Online Comment

Application H09-1107-17
Location 16-18 High Street Holbeach Spalding PE12 7DY
Proposal Proposed signage

Existing & Proposed Front & Side  
Shopfront Elevations

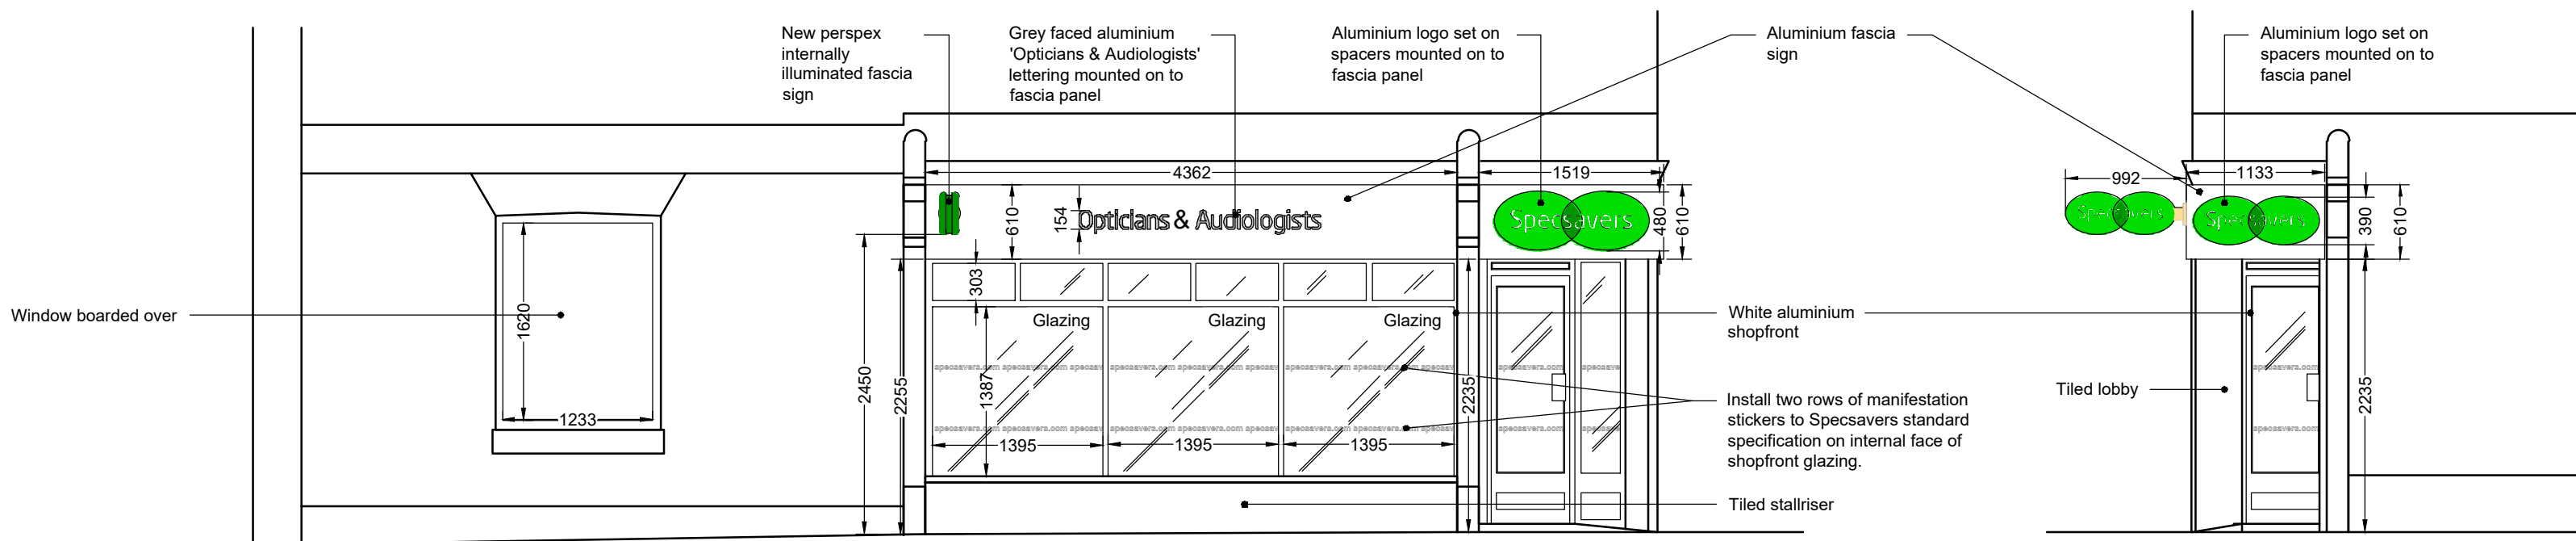
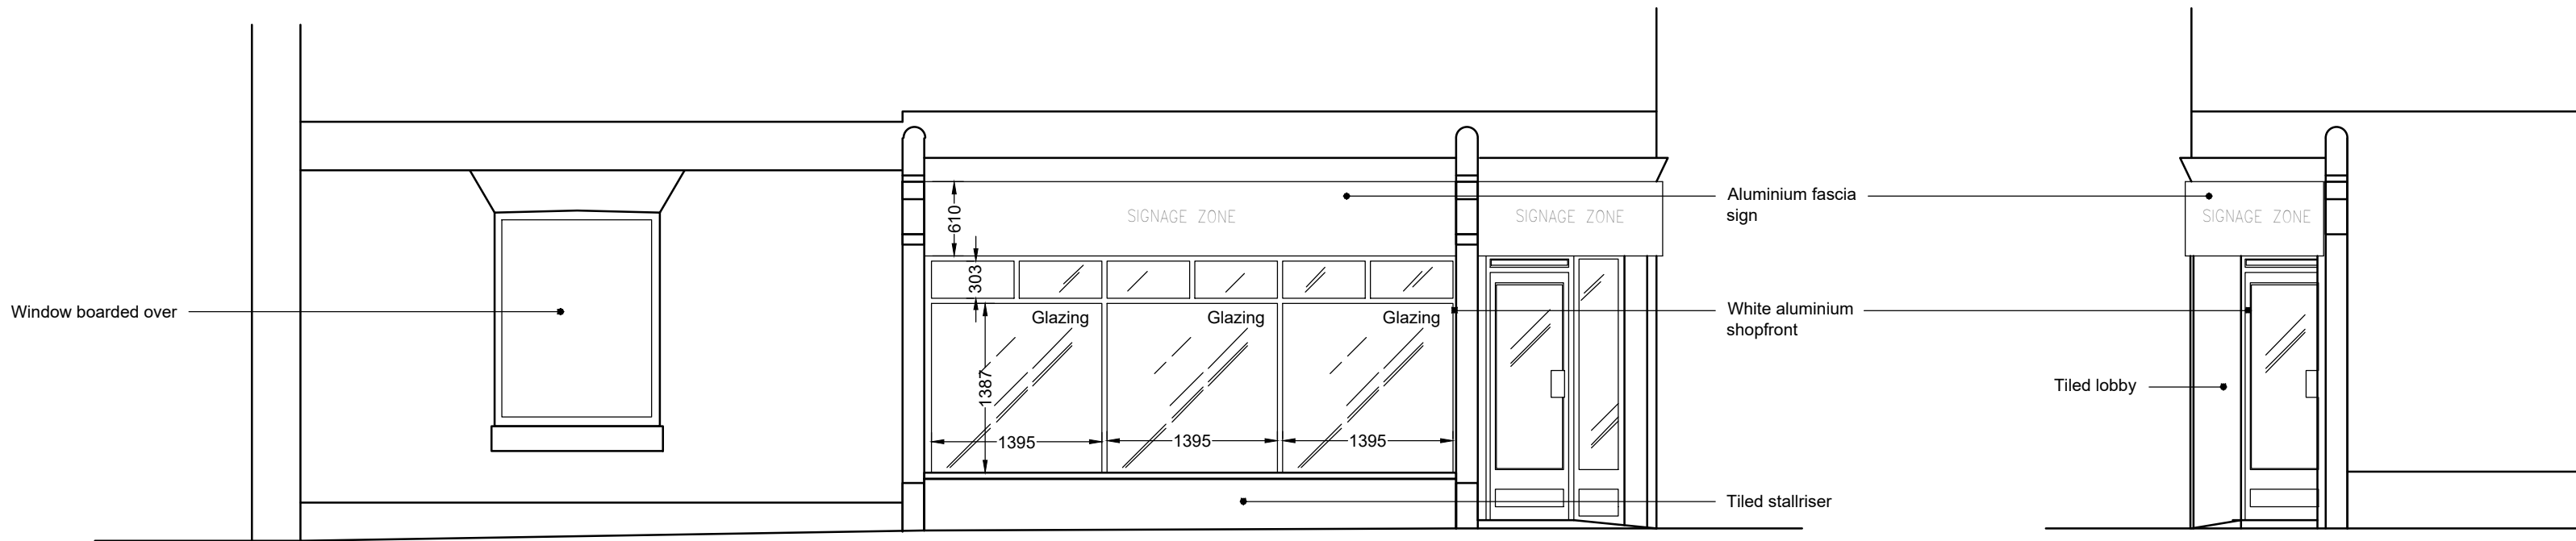
I feel the proposed signage is a clear improvement upon the existing and is acceptable in the context of the Conservation Area.

I note the sign is aluminium which is positive.
